Application for a non-material amendment following a grant of planning permission.
 Town and Country Planning Act 1990

ERECTION OF FRONT & REAR EXTENSION

2025/91863

LIFT ROOF HEIGHT AT REAR TO CREATE LEVEL FLOOR AND BASEMENT AREA.

Drg No	25/62	A	Rev
--------	-------	---	-----

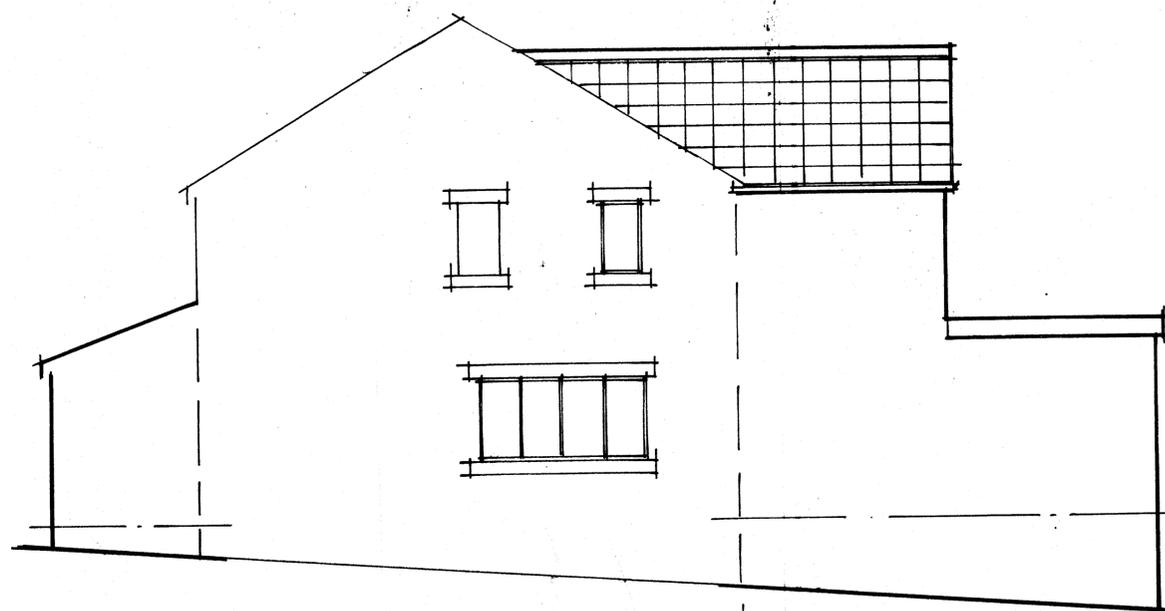
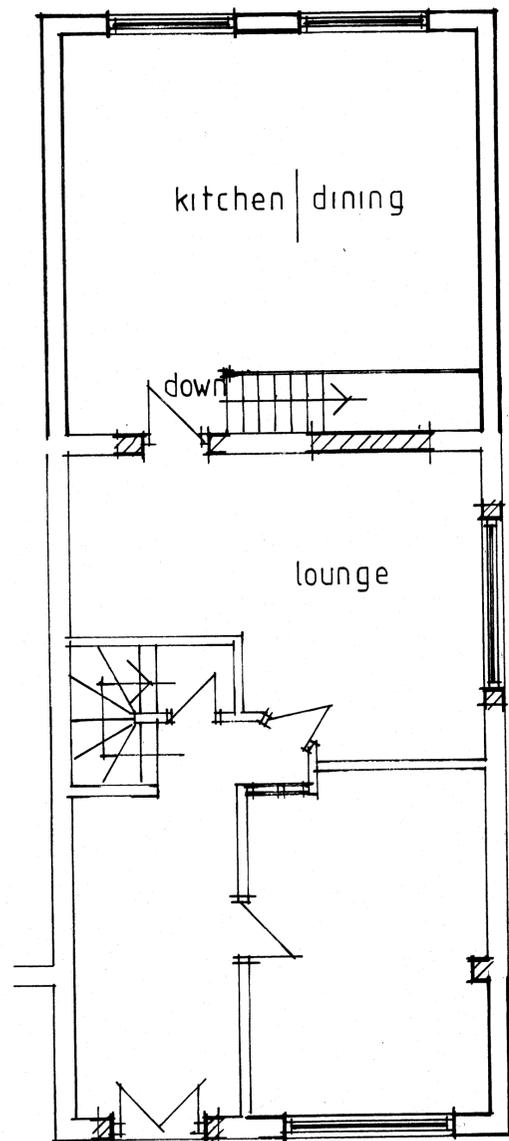
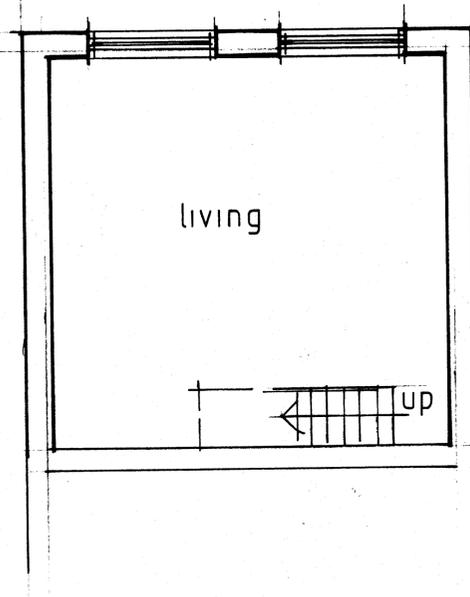
TO CREATE LEVEL GROUND FLOOR & BASEMENT LIVING
